Application by National Highways for A46 Coventry Junctions (Walsgrave) Project
The Examining Authority's written questions and requests for information (ExQ1)
Issued on 10th June 2025.

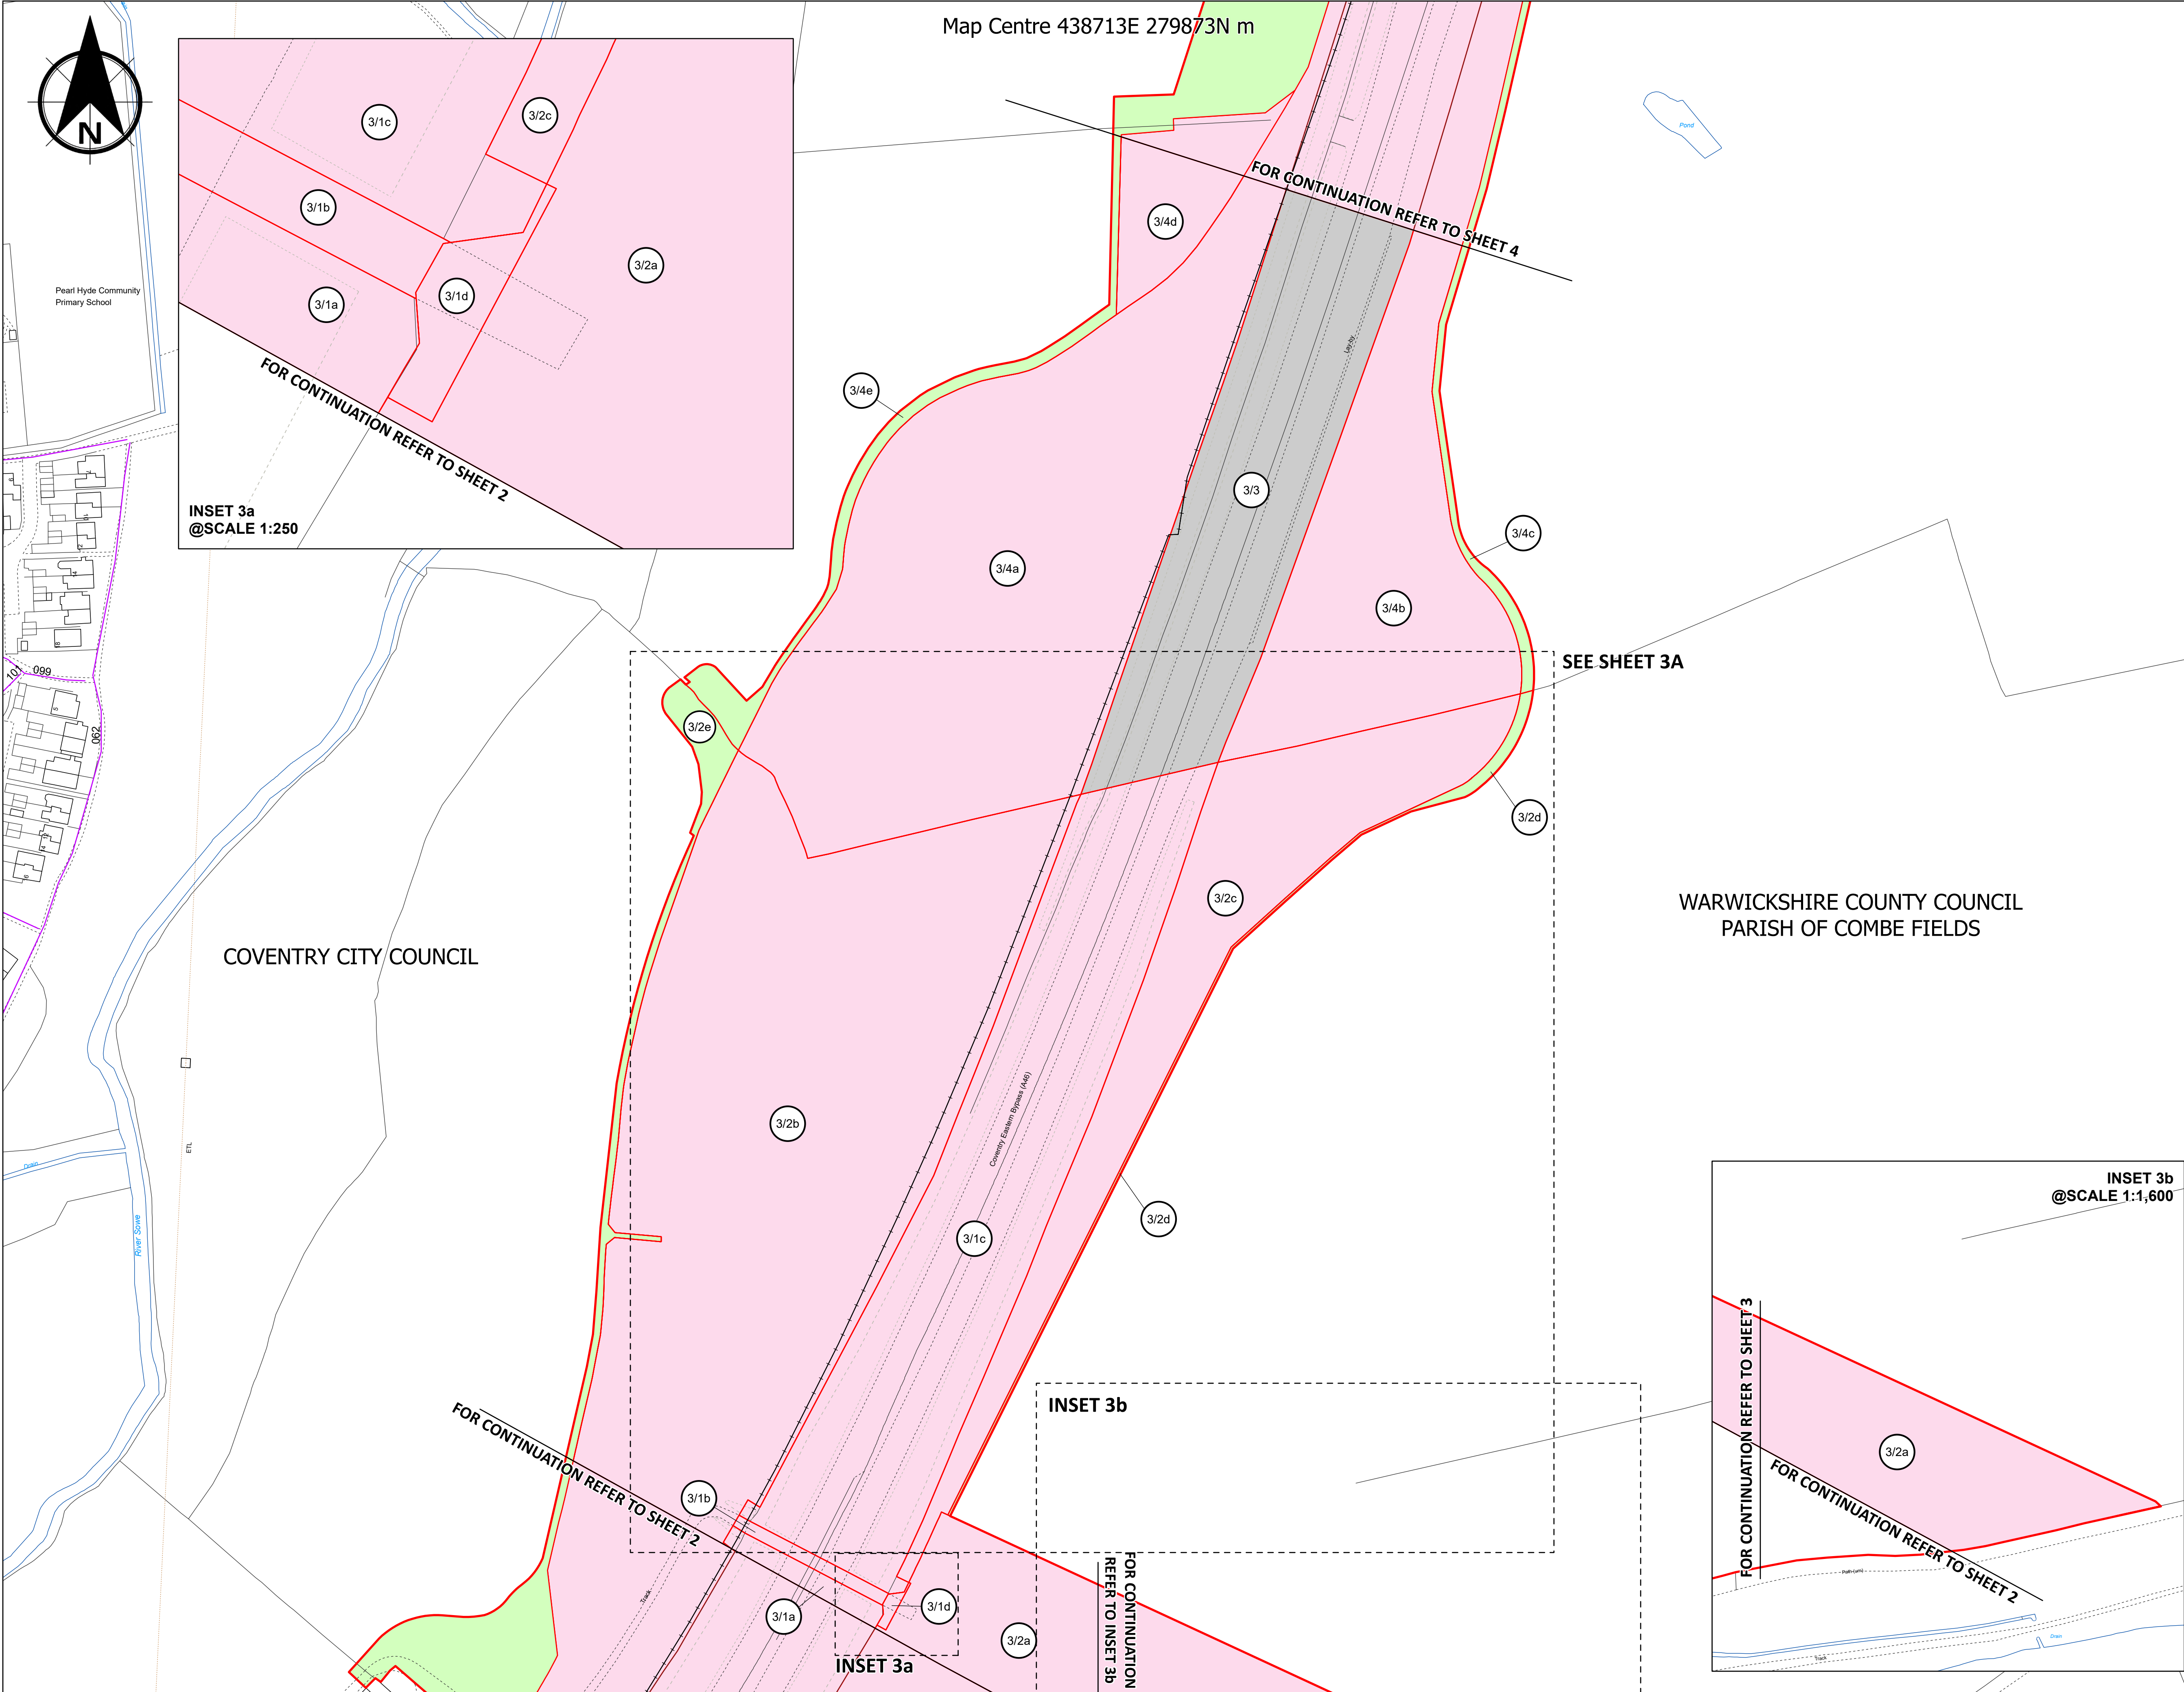
CA.1.2	The Applicant	Book of Reference [AS-016] Page 120 – Plot 3/3

ExQ1	Question to:	Question:
		There are no other interests other than the Applicant indicated and it is also shown coloured for permanent acquisition on sheet 3 of the Land Plans APP-012. Explain why powers are being sought for this parcel of land?
CA.1.3	The Applicant	<p>Funding Statement [AS-006]</p> <p>Paragraph 3.1.6 states that the funding commitment was reiterated in the National Highways (then Highways England) five-year Delivery Plan 2020 - 2025, which was published in August 2020. An extract from this is provided at Appendix E of this Statement. A summary of the extracts is as follows:</p> <ul style="list-style-type: none">• National Highways committed to delivering the A46 (Walsgrave) scheme to support regional growth. This scheme along with others in the Midlands will increase capacity, improve the consistency of the roads and relieve congestion. <p>To date no Road Investment Strategy has been published for a period beyond 2025. At the time of publication, it is expected that the Chancellor of the Exchequer will present her Spending Review 2025 to Parliament on Wednesday 11 June 2025.</p> <p>In light of these, confirm to the best of available knowledge, that the funds remain available for the Proposed Development.</p>
